Ribble Valley Borough Council

**App no: 24.0864**

**Address: Conkers Day Nursery, Dewhurst Road, Langho**

**Proposal: Change of use from day nursery (Use Class E (f)) to a mixed use including day nursery and education facility (sui generis).**

Revision
Project
Conkers Day Nursery
Address
Dewsbury Rd,
Langho, BB6 8AF
Client
Prosperity Children's Services
Drawing
Plans as Proposed

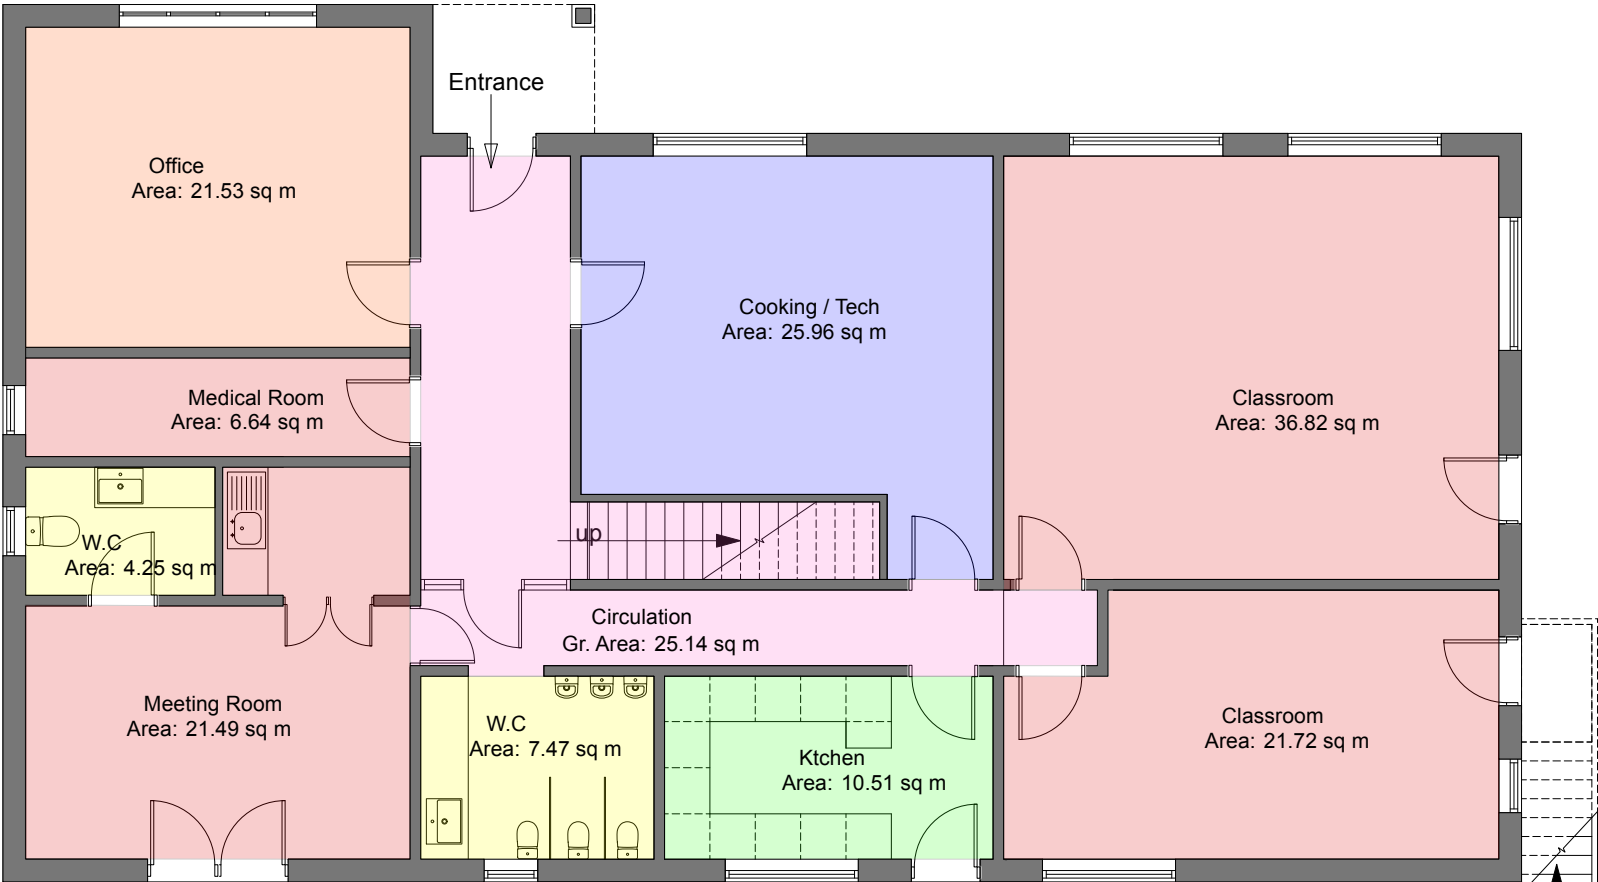
There are no changes to the existing parking provision proposed which shows 10 spaces marked out within an existing area of hardstanding adjacent to the Nursery.

We had originally requested that due to the combination of the two uses proposed, we would request that the number of children on site is provided with an analysis of the parking requirements based upon the standards to demonstrate that the existing provision is suitable. This information has not been provided, and we have a number of outstanding concerns arising from the proposal.

The current use as a nursery has a significant shortfall in car parking so the proposed mixed use would reduce the parking impact in theory however in reality we know that schools generate significantly more car parking than the standard suggests. The shortfall is significantly increased where the children have special needs as the staff to child ratio is significantly higher.

The shortfall in car parking would likely be disruptive to neighbouring property accesses as drivers would likely park on the access road and there is no suitable place to turn. They may park on neighbouring car parks at The Healing Centre or the Sports Club and walk to site but there are no separate footways which may present a concern if there is also parking occurring.

Lancashire County Council acting as the Highway Authority would request additional information regarding the car parking provision and its management to ensure that there is no adverse impact upon highway safety.
